Our Ref: 7476/LRW/kc

Date 13th February 2024

Re: **Land rear of Chicane and Quintons, Ockham Road North, East Horsley, KT24 6PU** – Condition 8 Ref LLFA-GU-22-0445 Rev B

Further to the recent holding objection relating to the clearance of Condition 8 of the reserved matters planning approval for this site we enclose our response to queries along with supporting documentation.

DRAWING  
**Adoptable Drainage  
Construction Details  
Sheet 2 of 2**

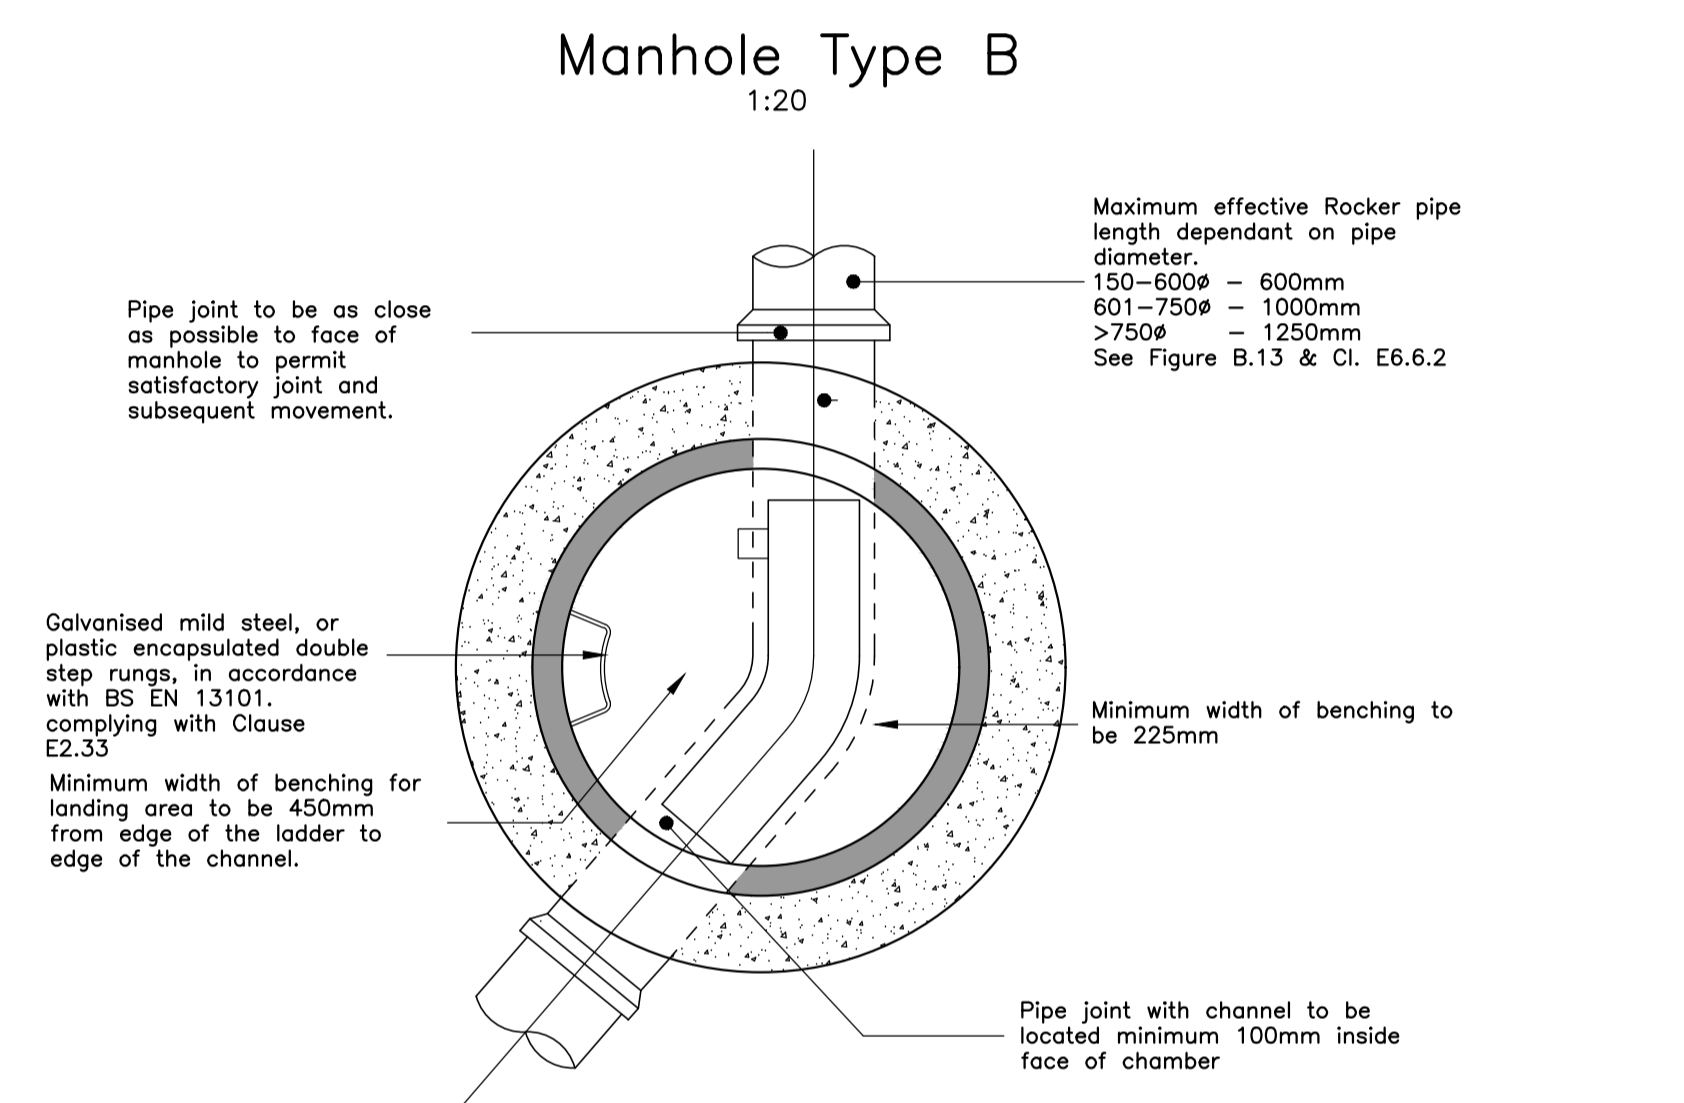
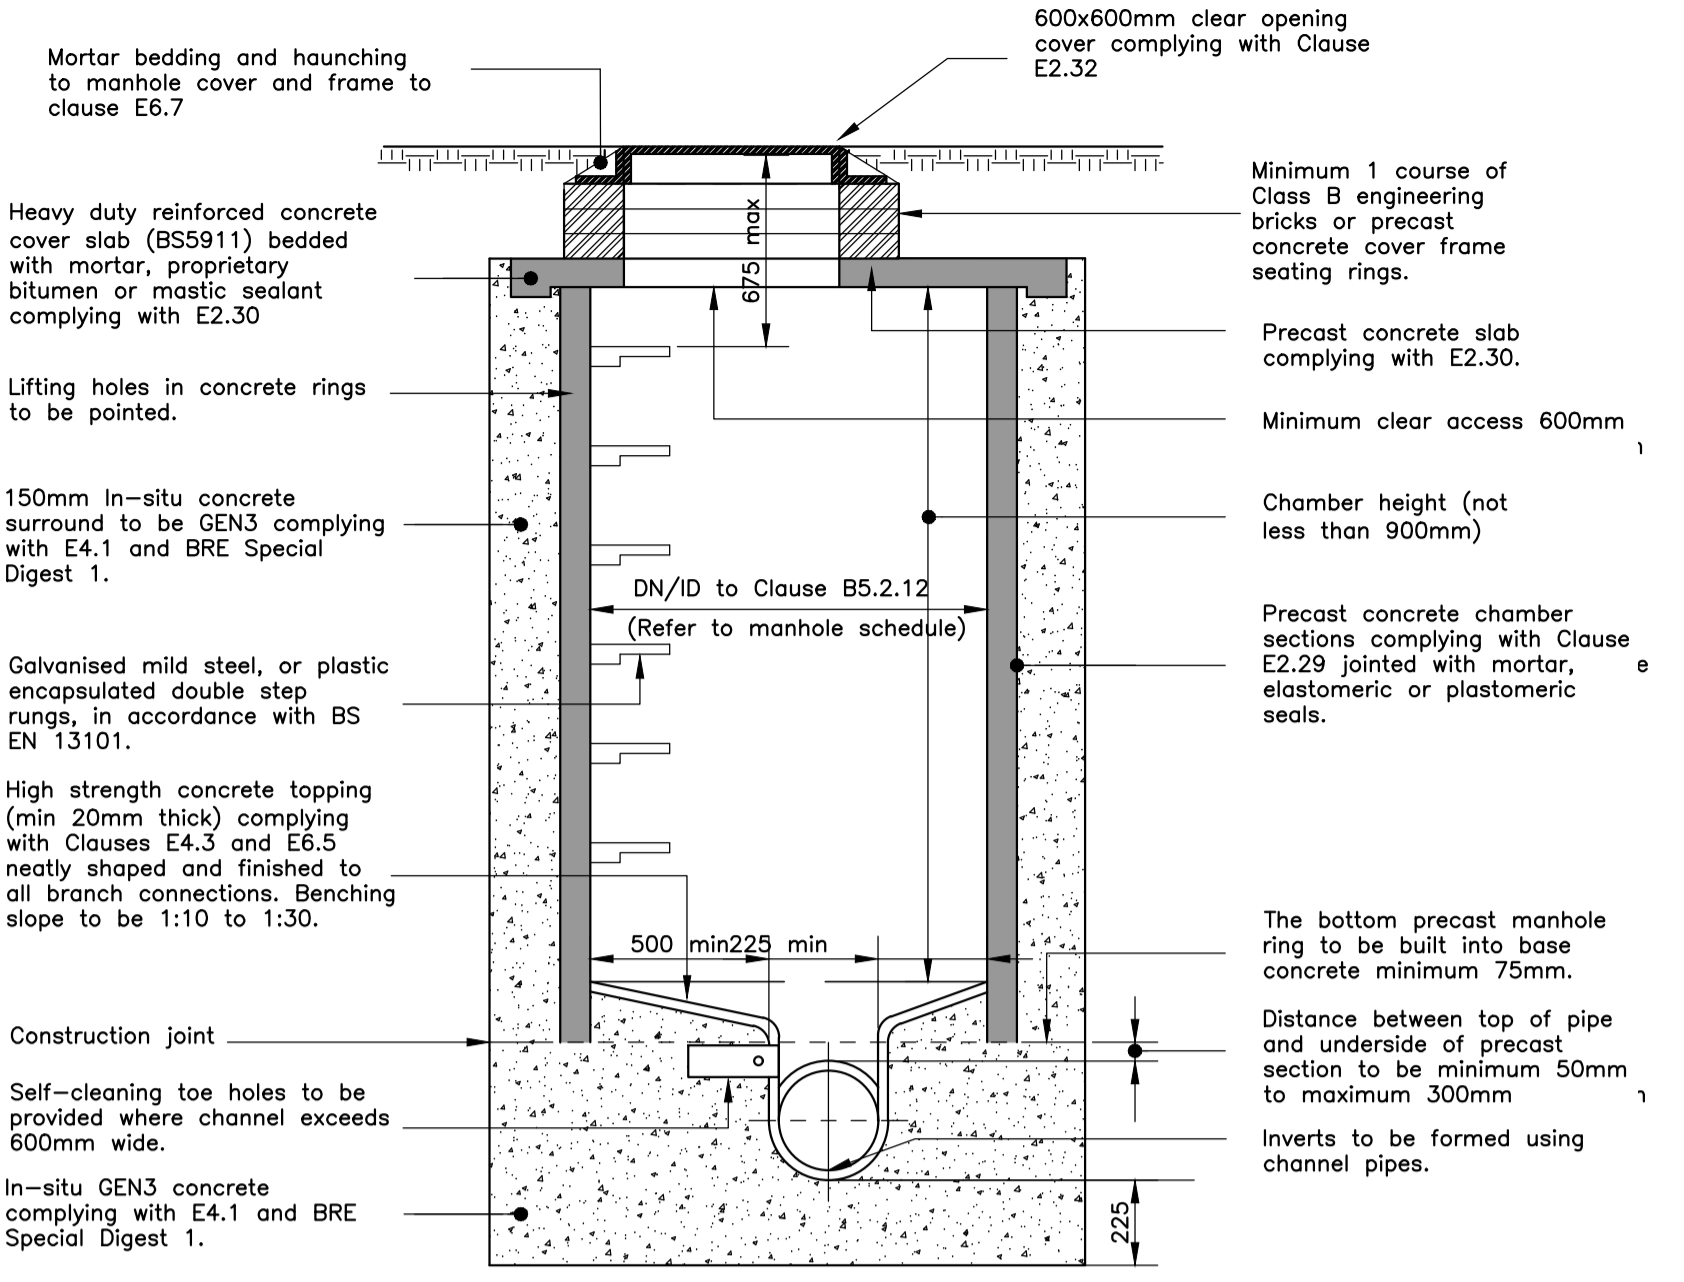
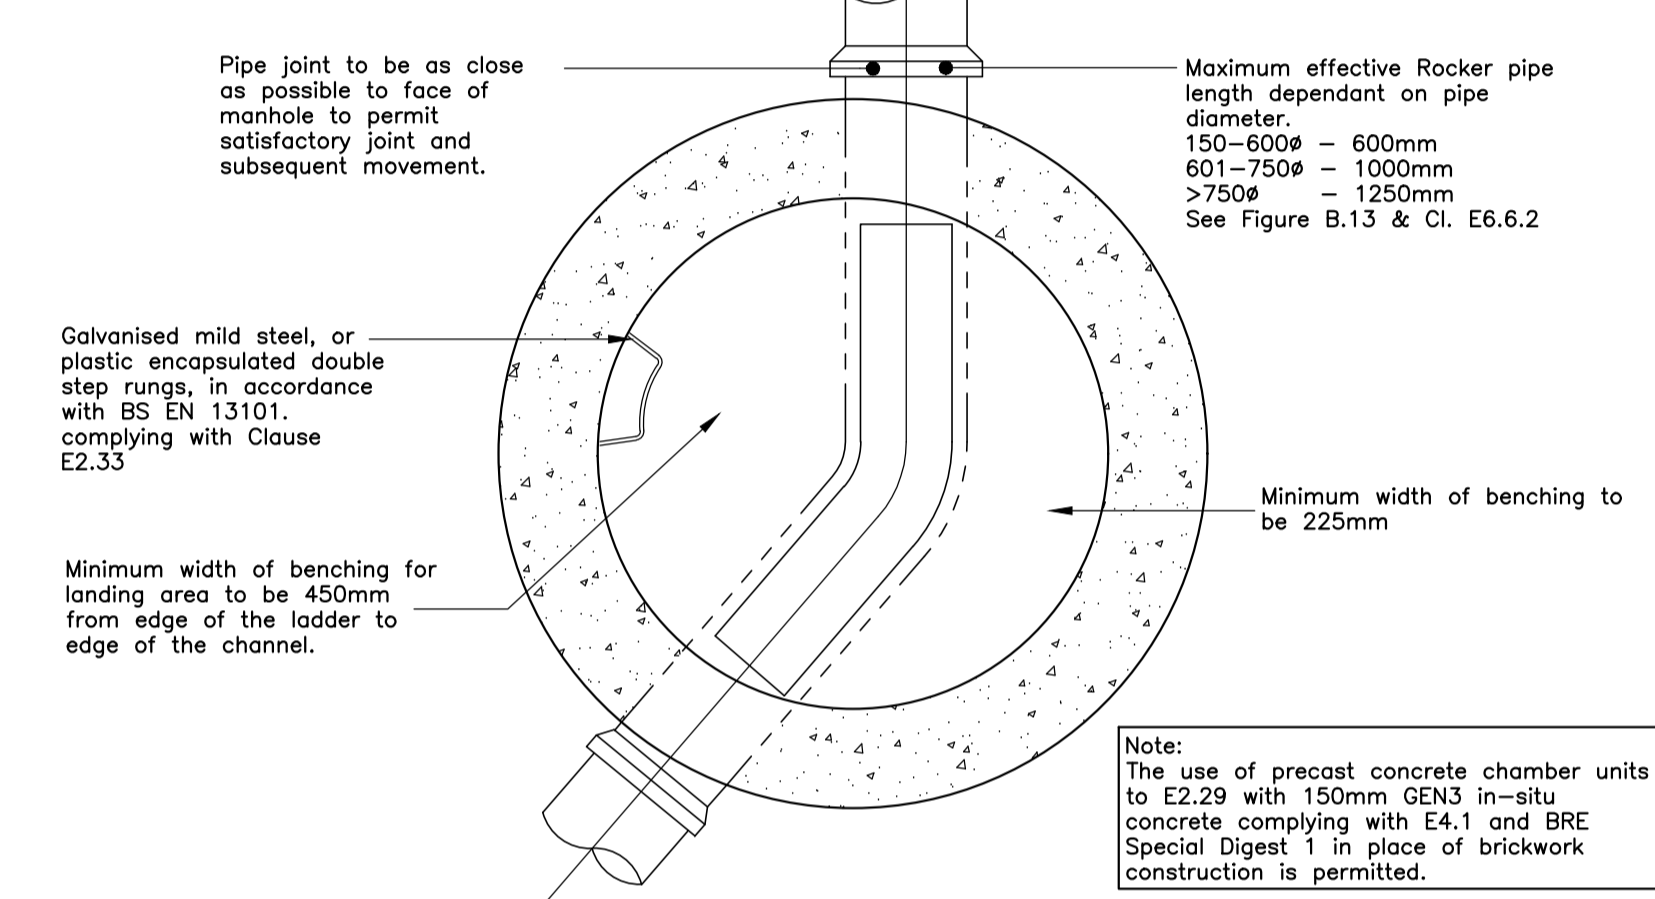
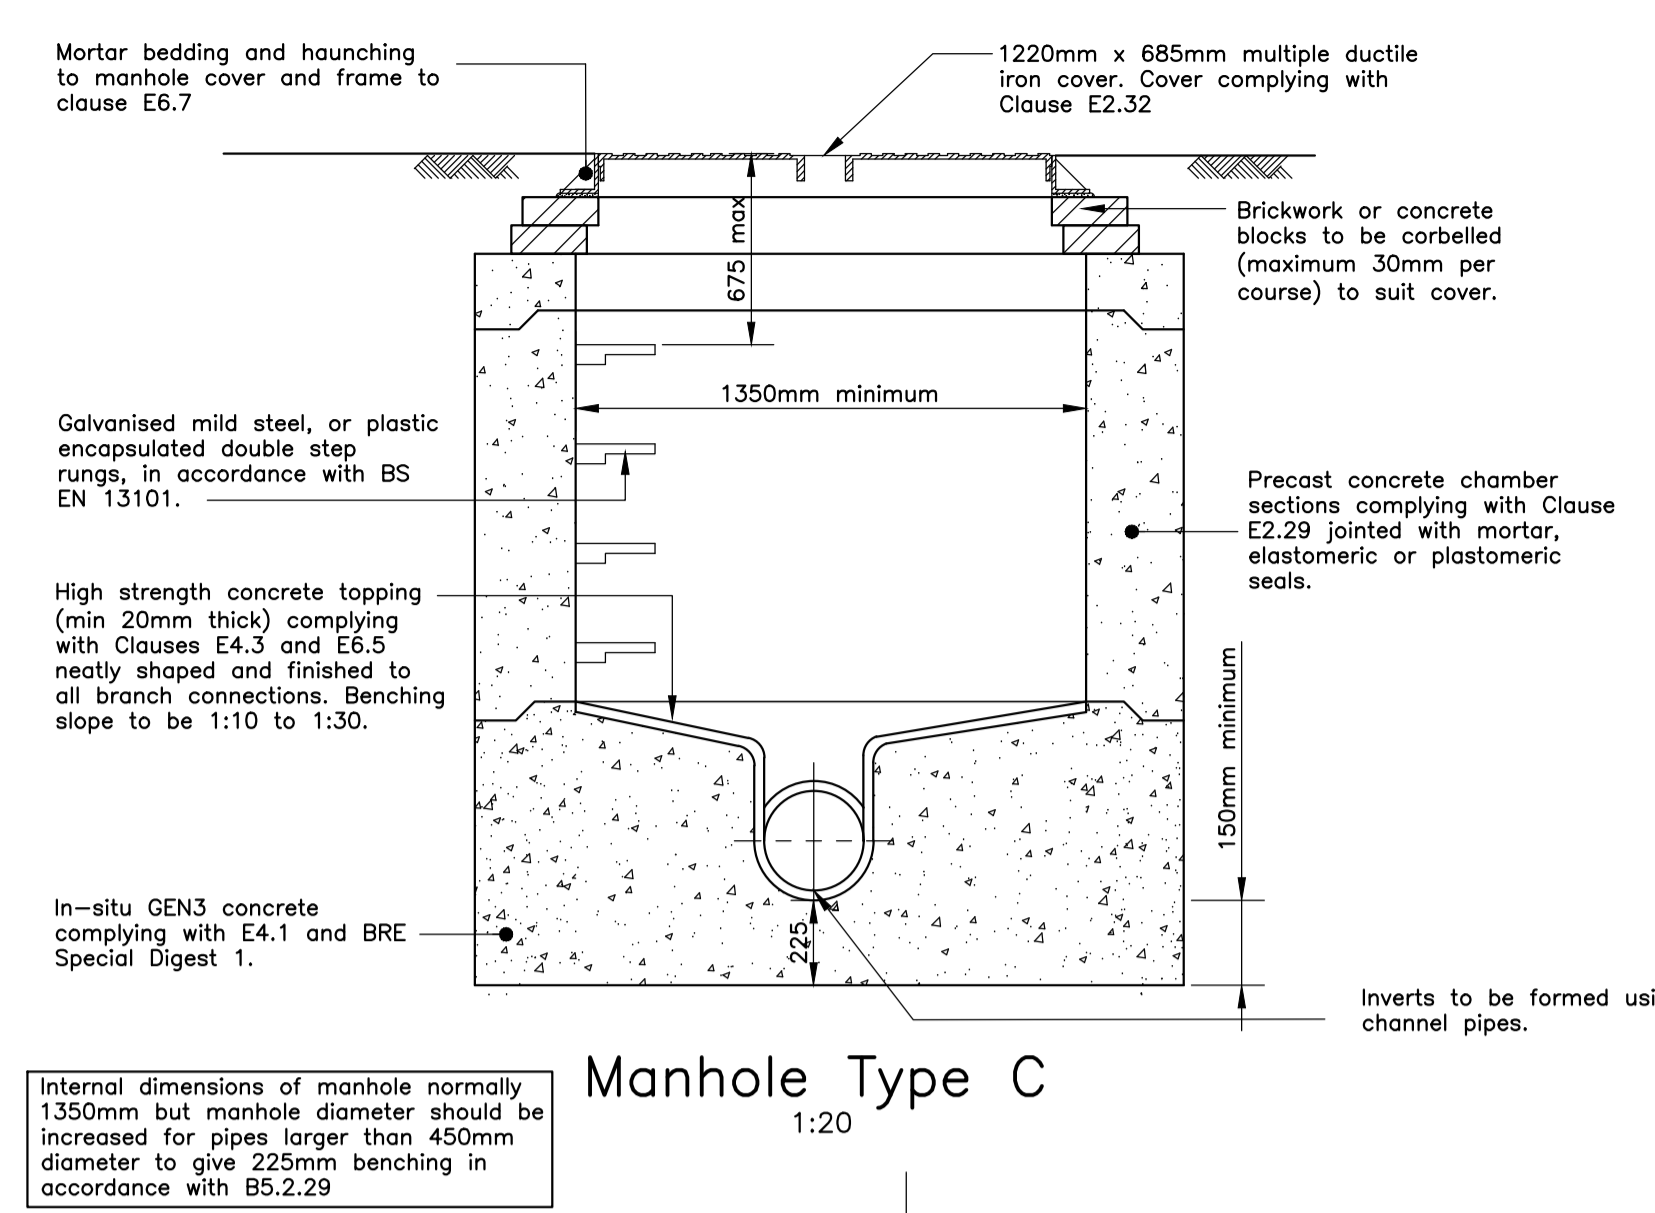
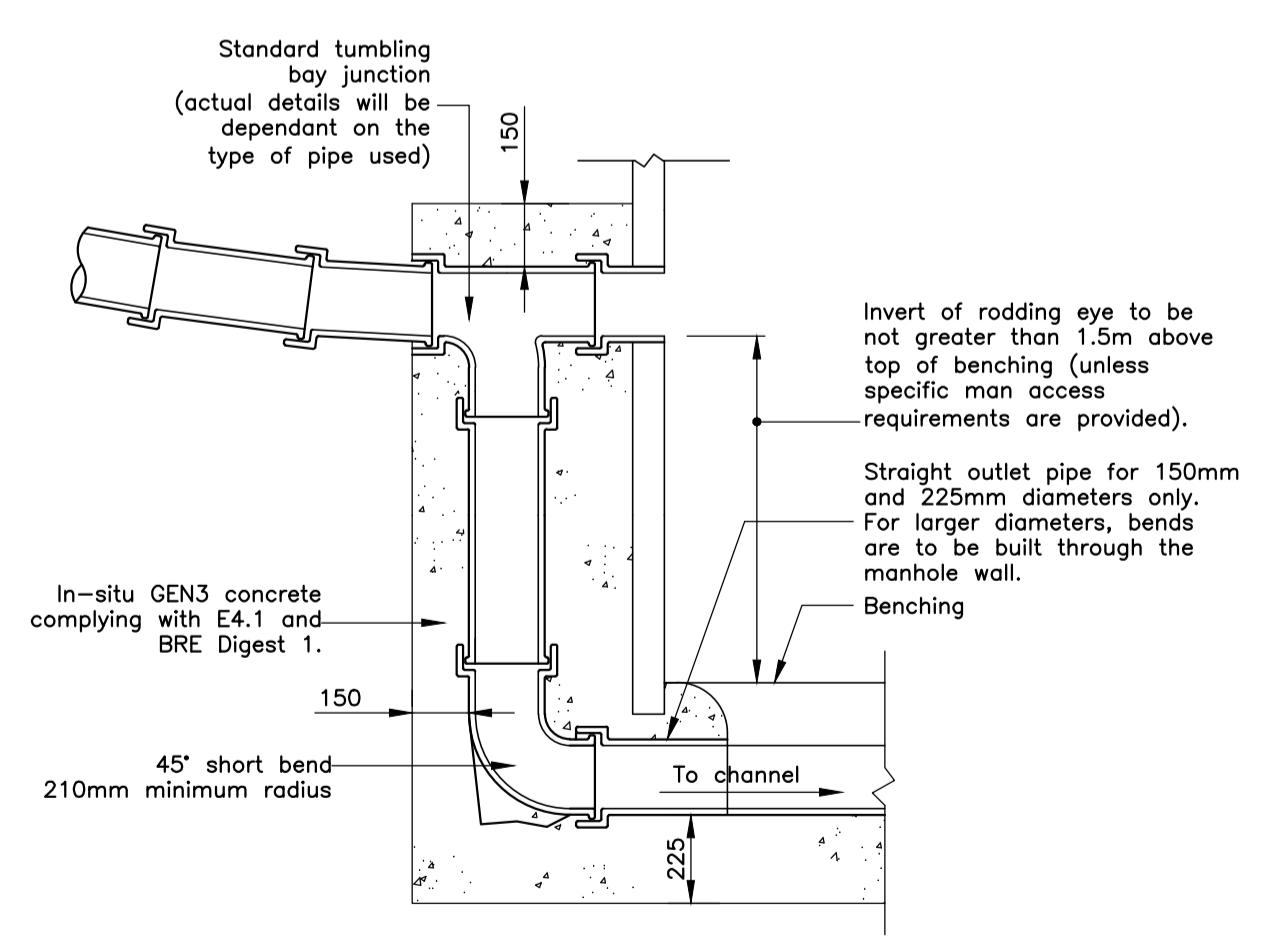
xi. Adoptable Drainage Construction Details – Sheet 1 of 2 provided however no sheet 2 of 2 submitted.

xii. Sheet 2 of 2 is provided with this response.
